Consultation Response from KC Highways Development Management
2019/93157 3-5, St James Street, Batley, WF17 5SA
Alterations to convert former restaurant to 3 apartments (within a Conservation Area)
Date Responded: 20/11/19 | Responding Officer: CNB | Responding Ref: K13-10SW/37

SITE PLAN
 SCALE: 1:500

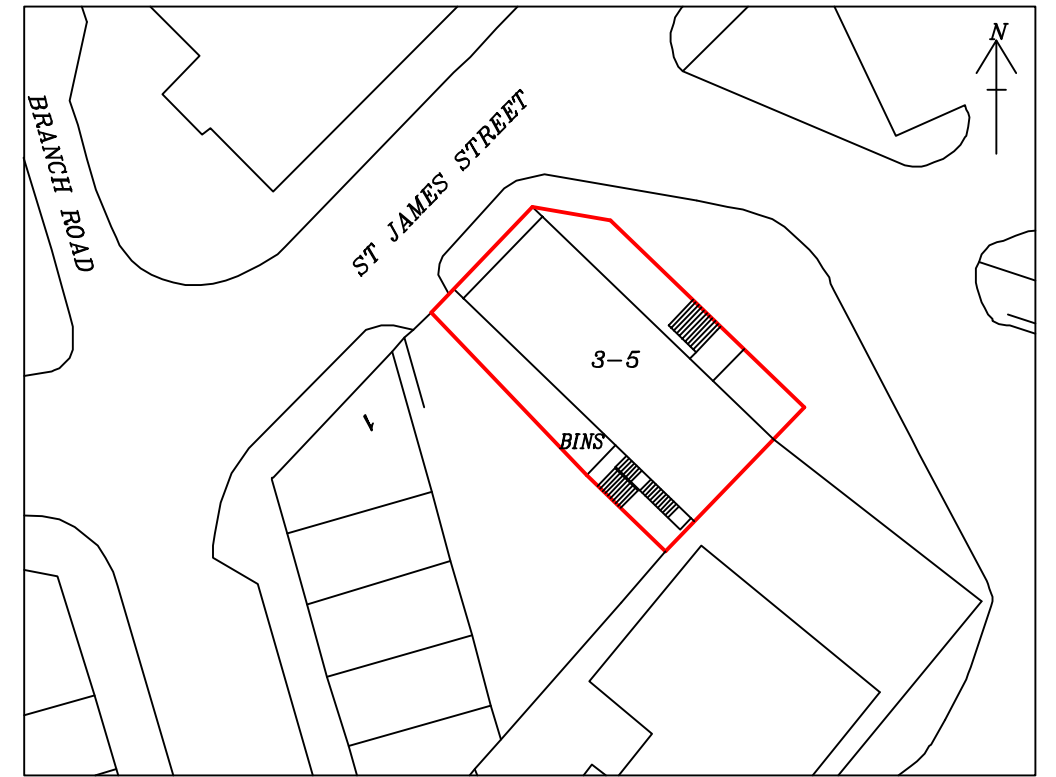
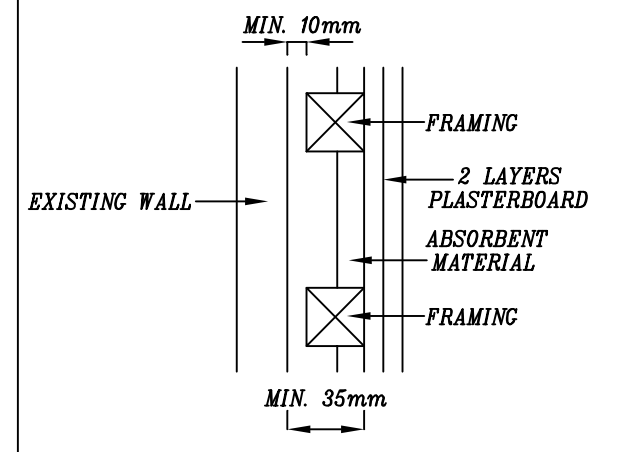
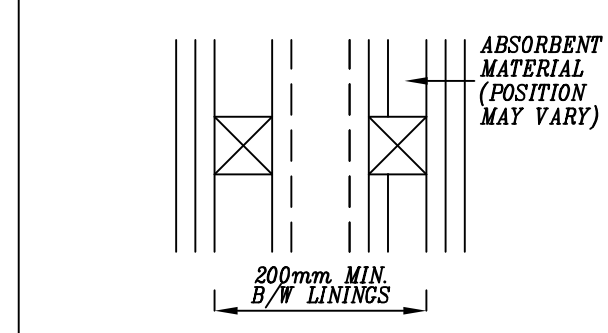
The bin storage/collection point shown on the site plan is acceptable, although the type and number of bins required should be in accordance with guidance supplied by the Kirklees Cleansing Department in the document “Waste Storage and Collection Guidance for New Developments” which is available from trade.waste@kirklees.gov.uk.
